**WEST SUSSEX COUNTY COUNCIL
STRATEGIC PLANNING CONSULTATION**

DATE: 1st September 2015

SUBJECT: BN/29/15/PL - Solar park including the erection of solar arrays, inverters, transformers, equipment housing, security fencing, internal tracks, ancillary equipment and ecological mitigation. This is a Departure from the Development Plan.

Land at Barnham Court, Church Lane, Barnham, West Sussex

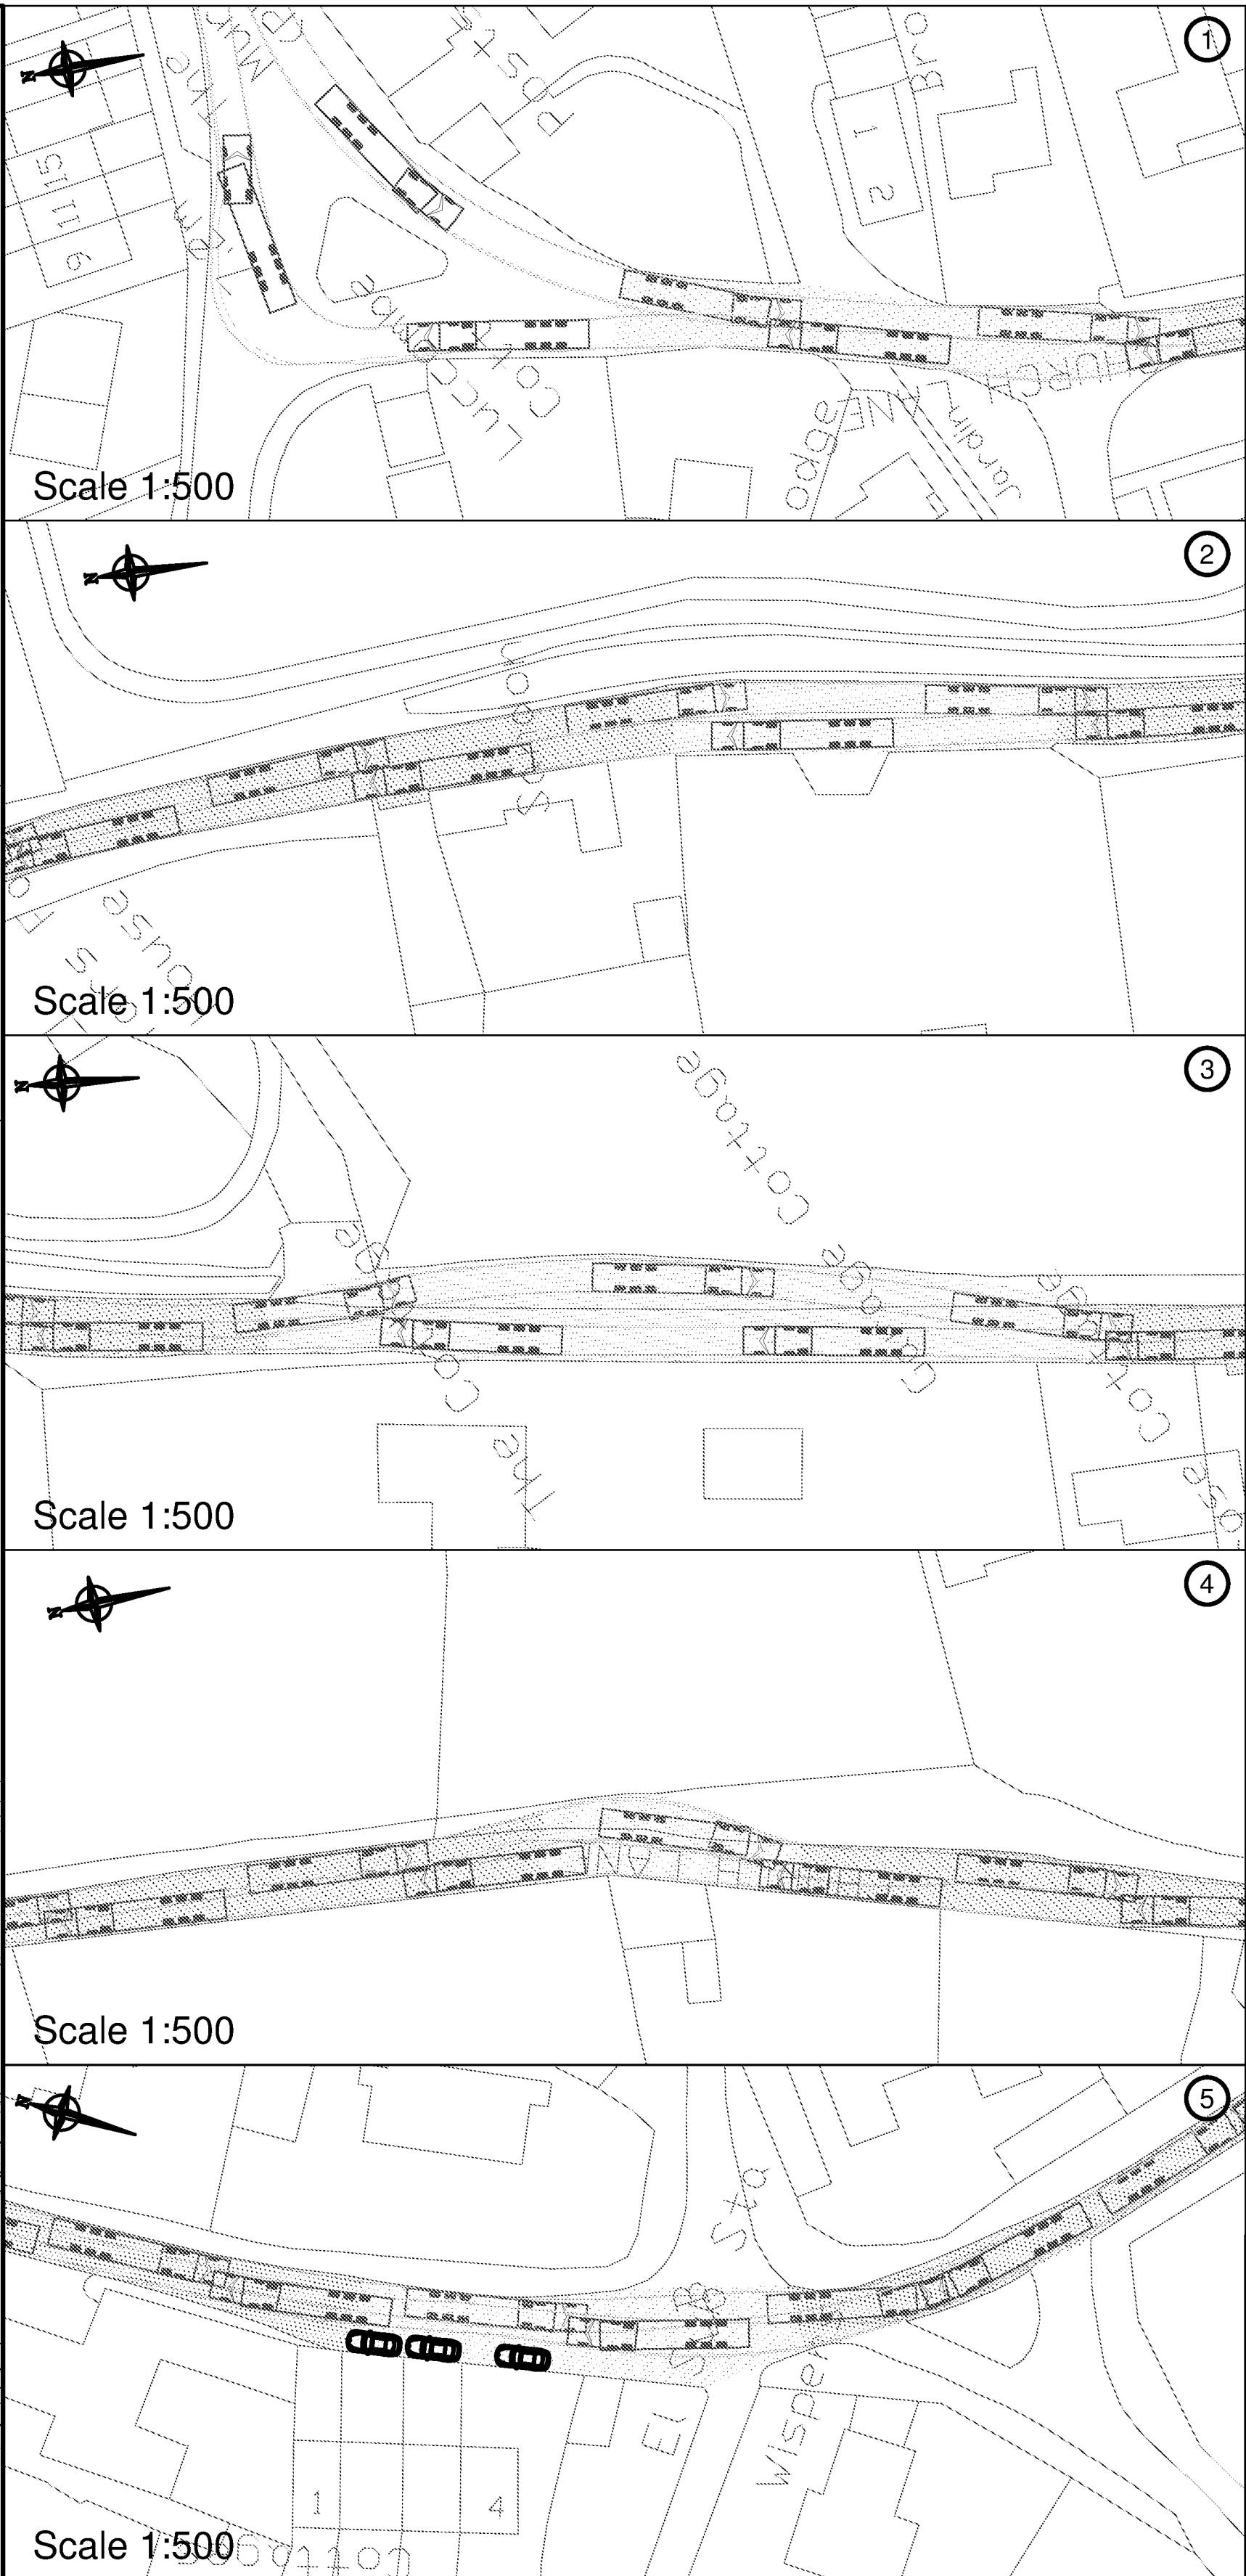
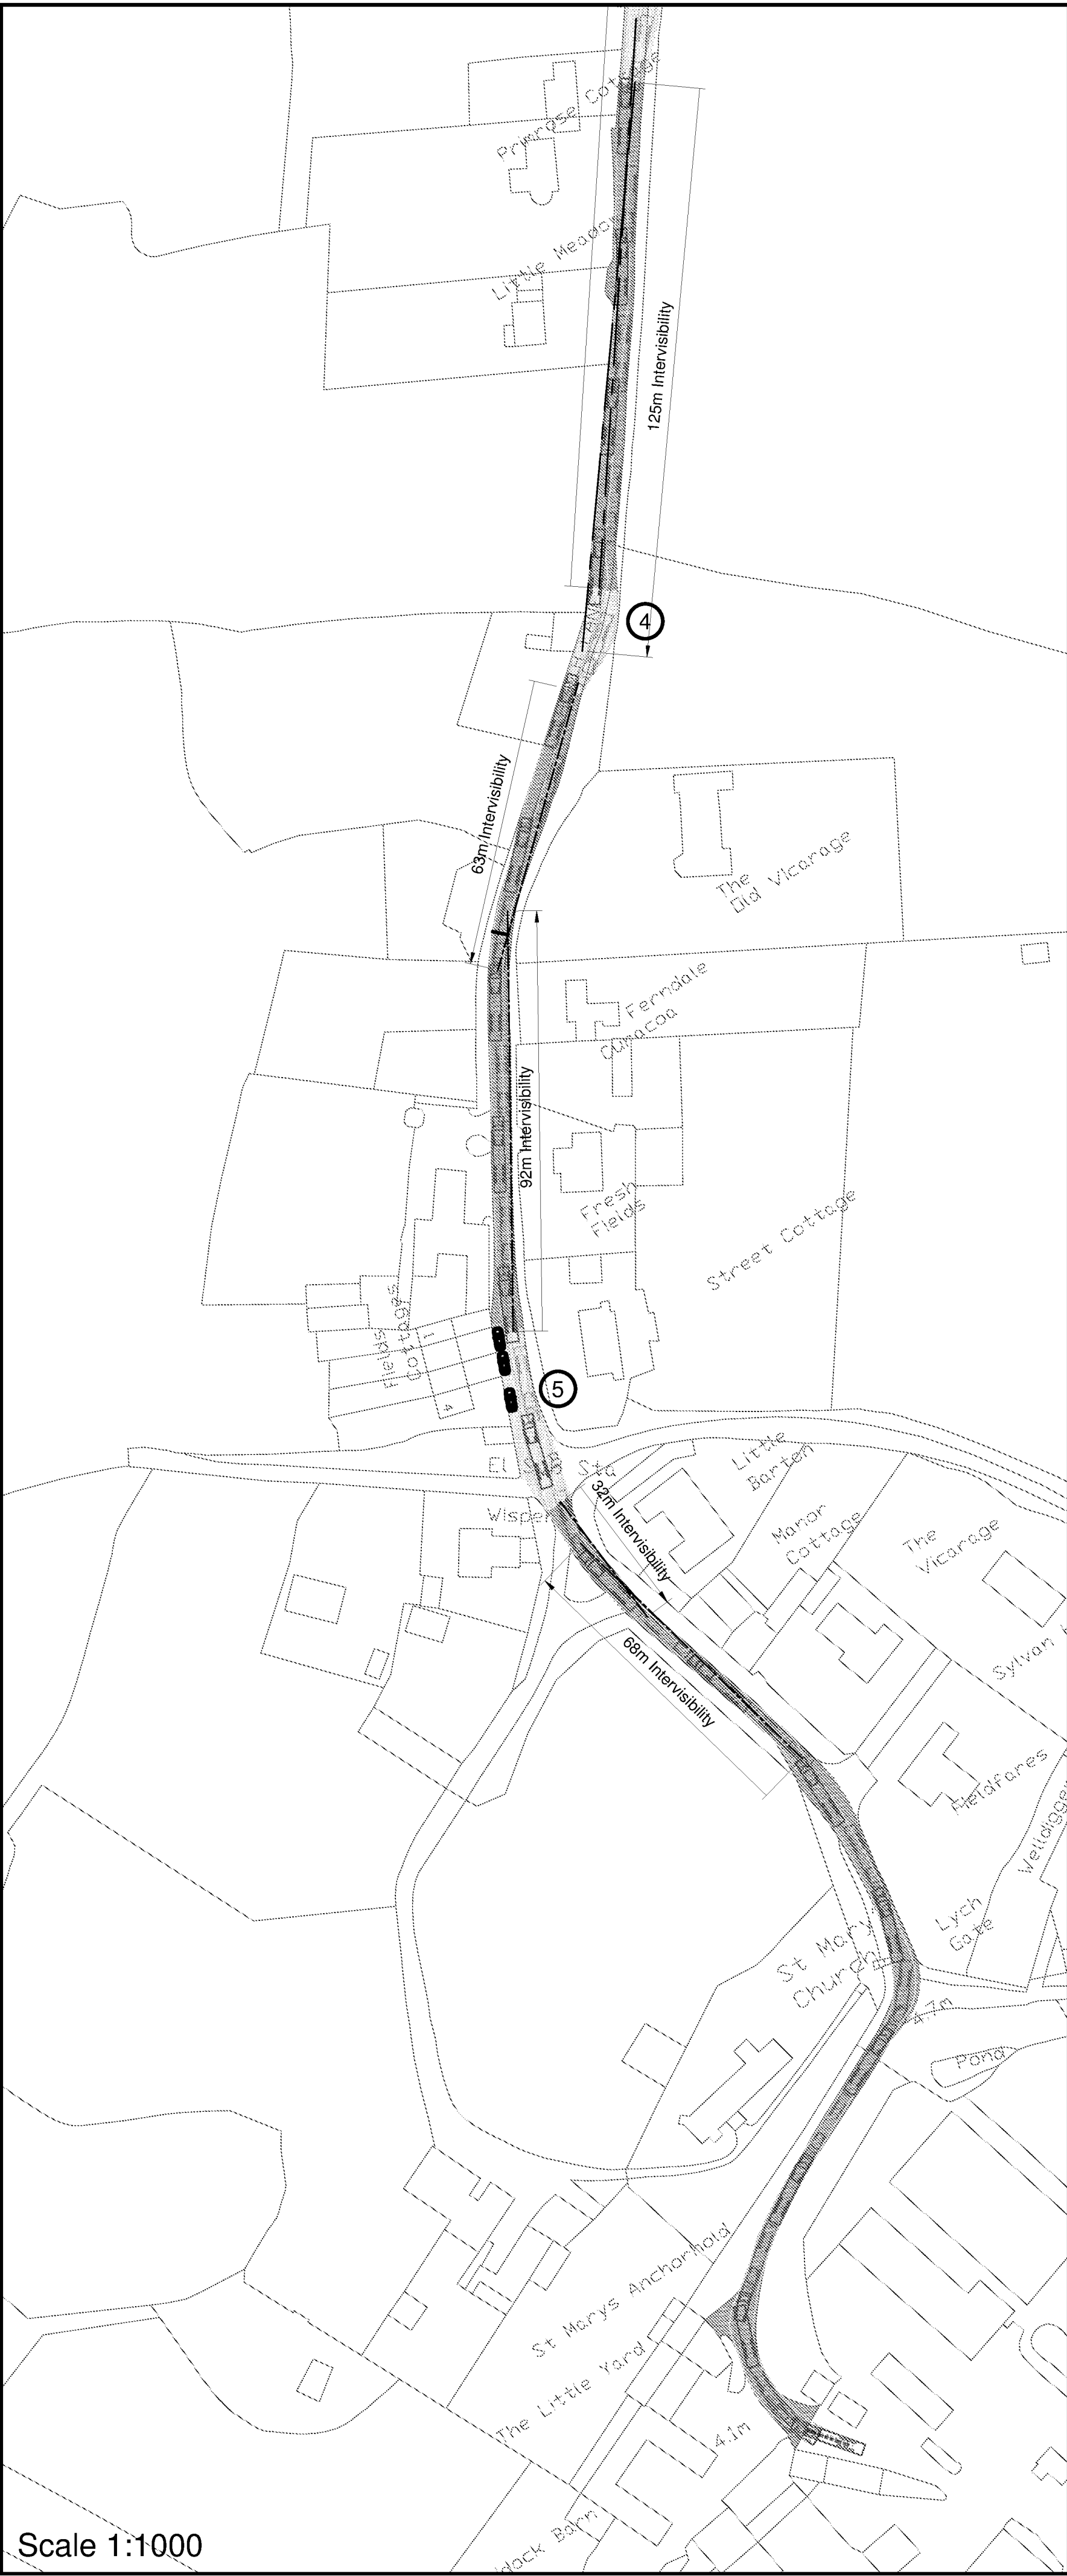
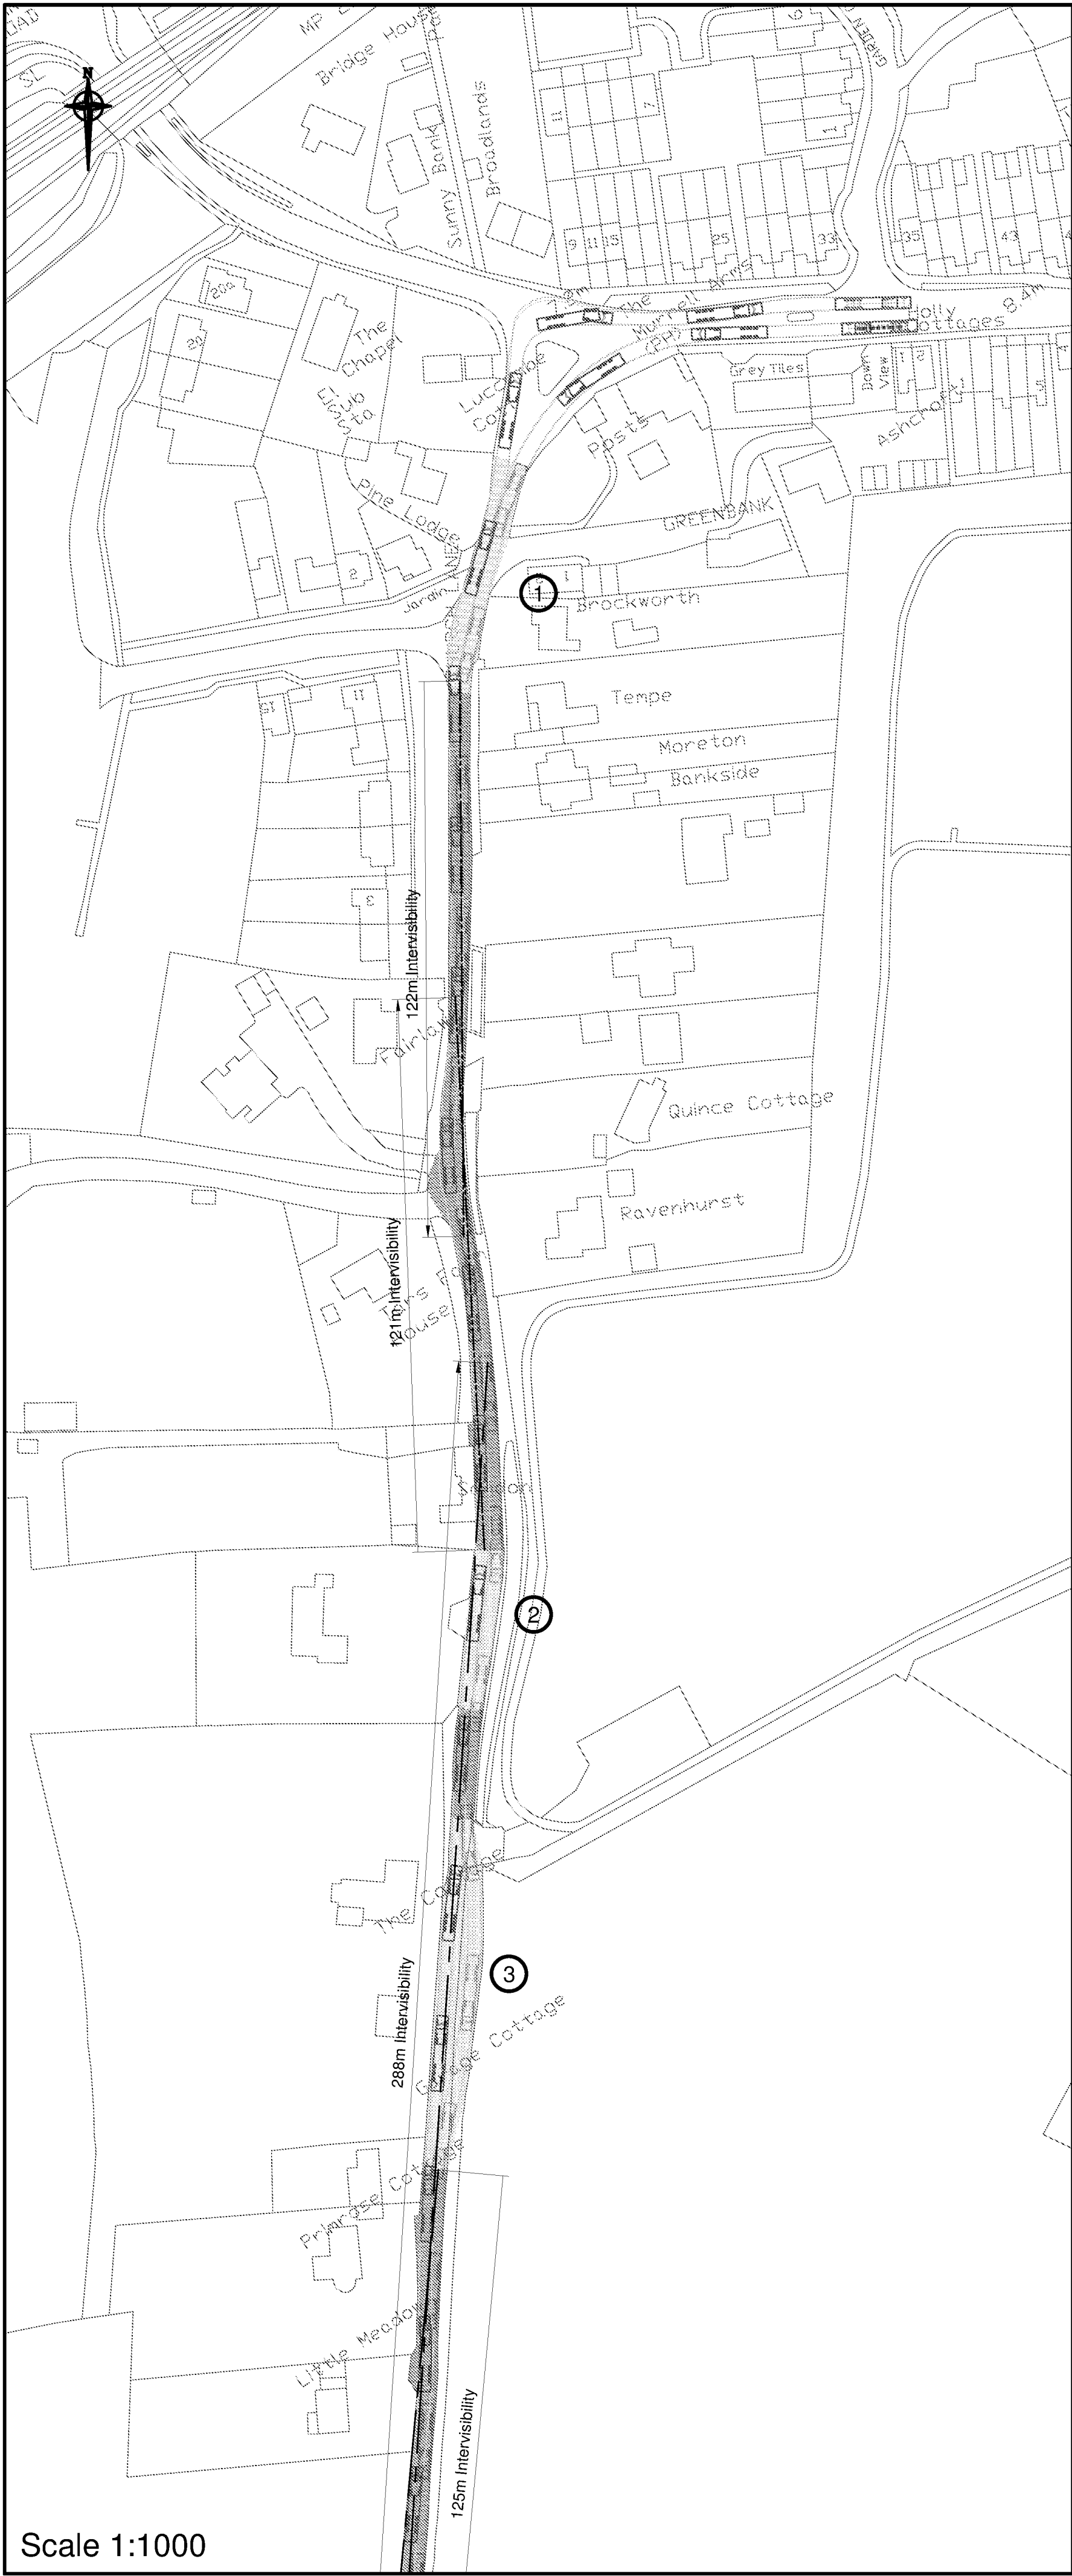
Swept path diagrams show a HGV using this junction without any problems however; parking associated with the Murrell Arms Public House and local residents does occur at this junction. These diagrams do not take into account parked cars, and with no parking restrictions to prohibit members of the public from using the road for parking here, could causing problems for a HGV to enter and exit the junction safely.

WSCC would like to see additional diagrams to include parked cars, or a plan to temporarily restrict parking during the construction phase during the daytime.
